**Planning Act 2008 The Infrastructure Planning (Examination Procedure) Rules 2010
Application by Fosse Green Energy Limited for an Order granting Development
Consent for the Fosse Green Energy Project Planning Inspectorate Reference
Number: EN010154**

**Deadline 1: Written Representation and Summary submitted on behalf of National
Highways Limited**

Drawing file: published-documents / EN010154-000149-6.2 Fig 3-13 Typical Trenchless Crossings Cross Sections.pdf

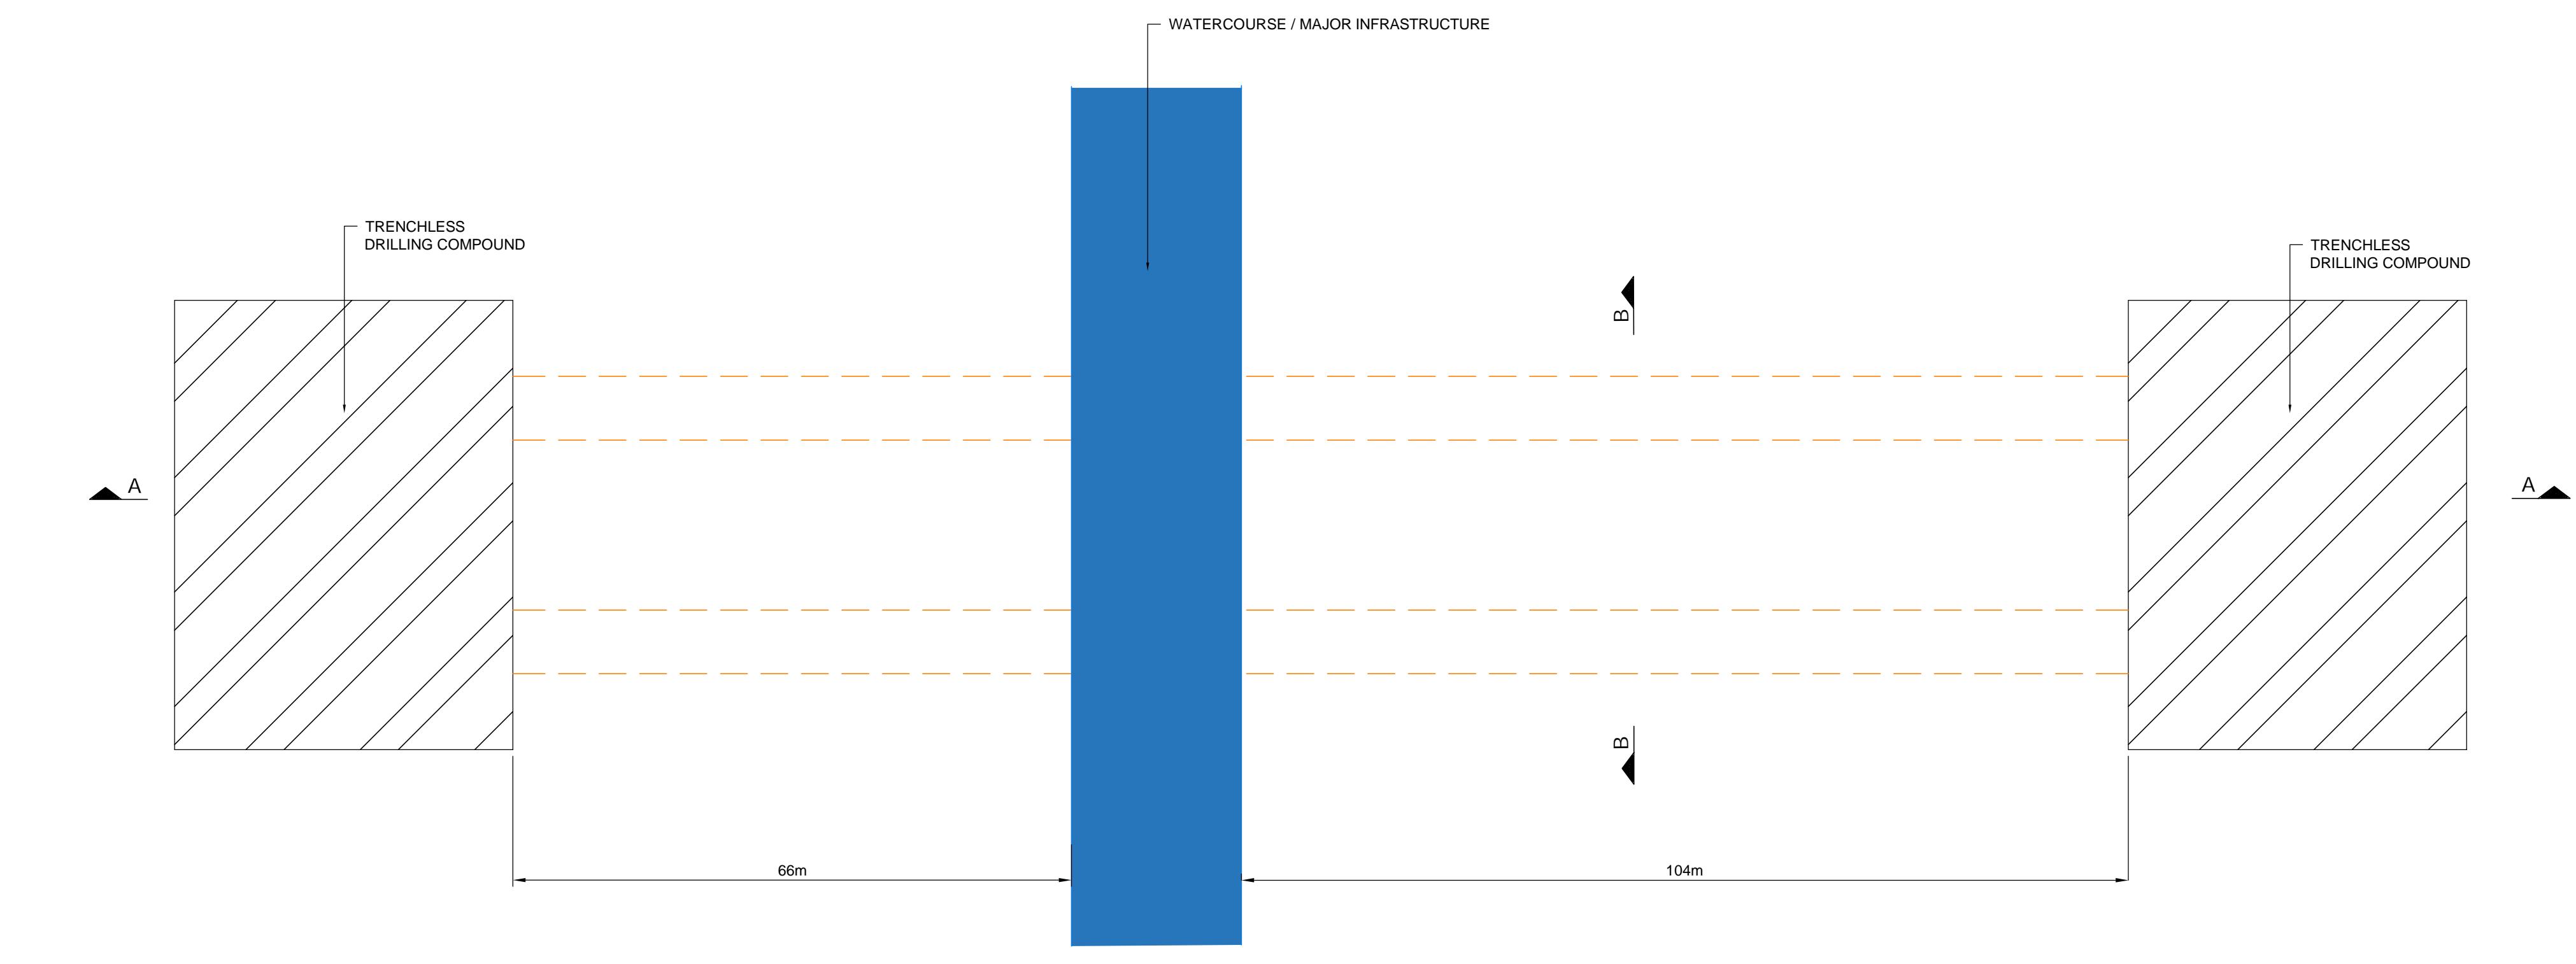
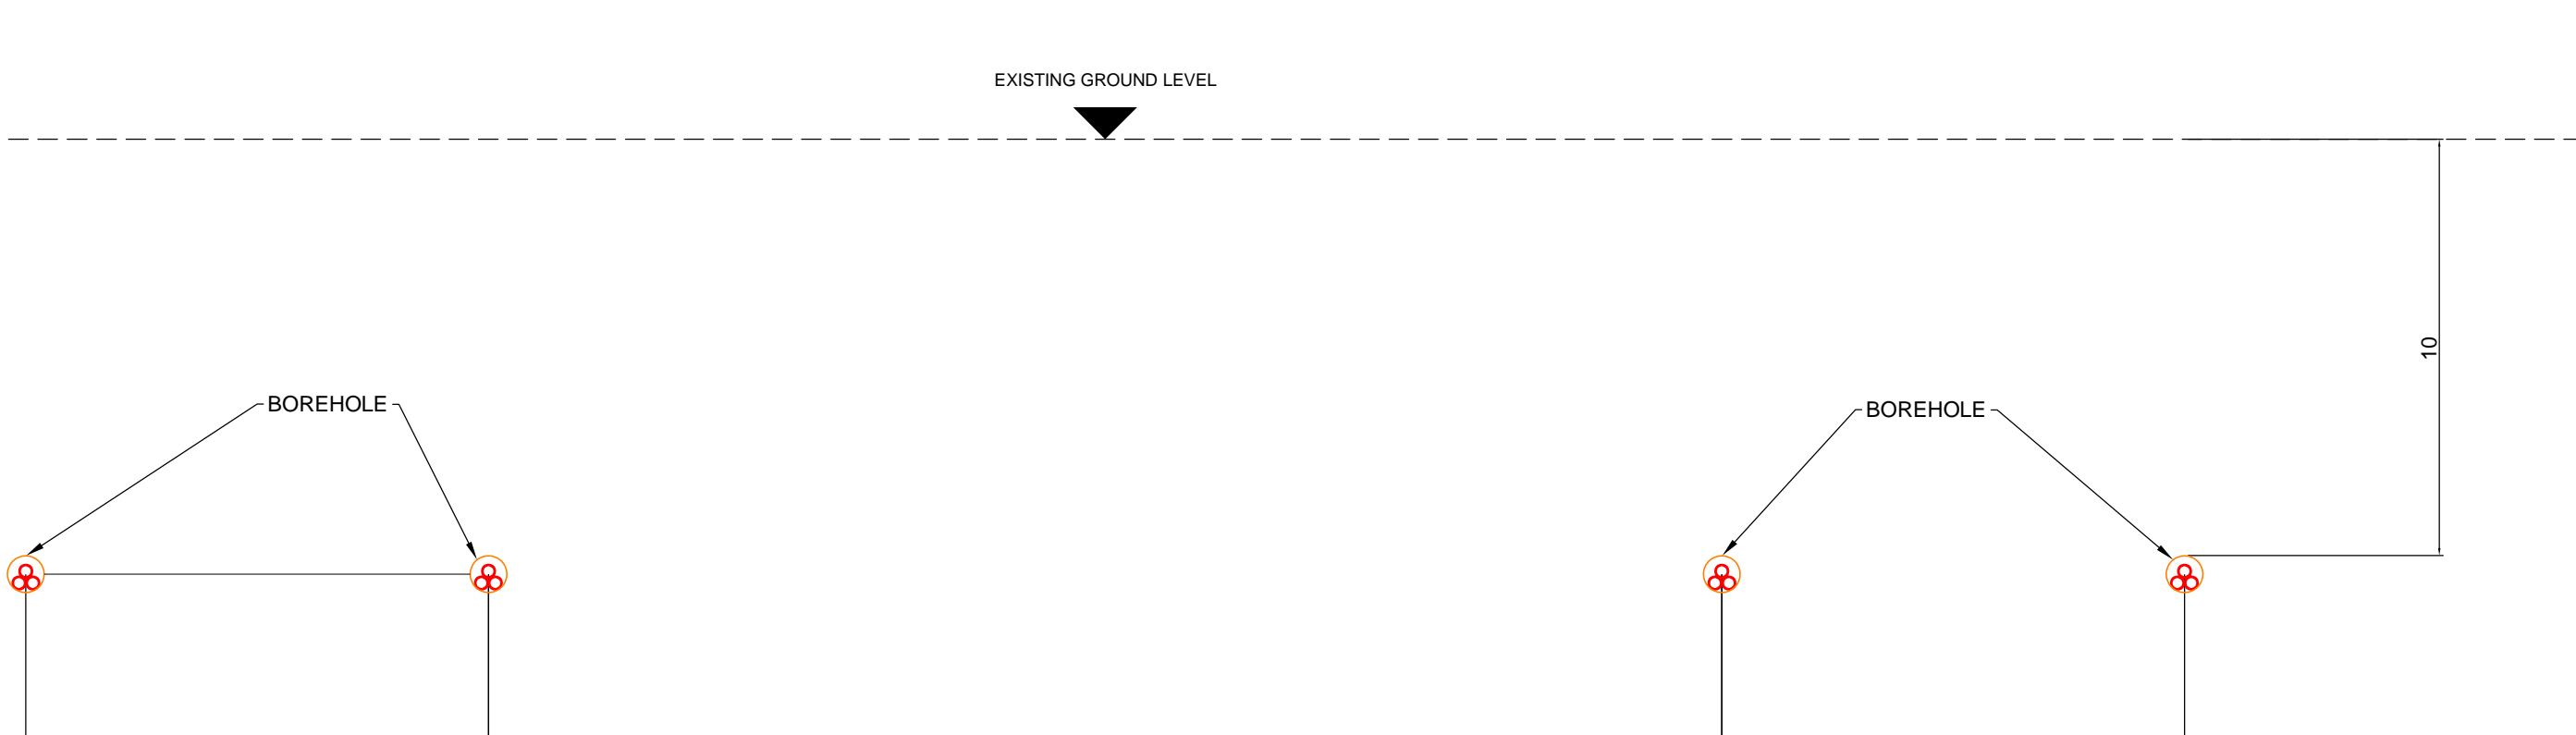
- c) The cross-section information provided on ES Figure 3-13 Typical Trenchless Crossings Cross Sections (APP-060) is insufficient to determine the geotechnical risks on the A46 trunk road and its assets, including drainage. Any proposed directional drilling under the SRN will require compliance with The Design Manual for Roads and Bridges (DMRB) Chapter CD622 (Managing Geotechnical Risk). **This requirement can be addressed in the protective provisions.**
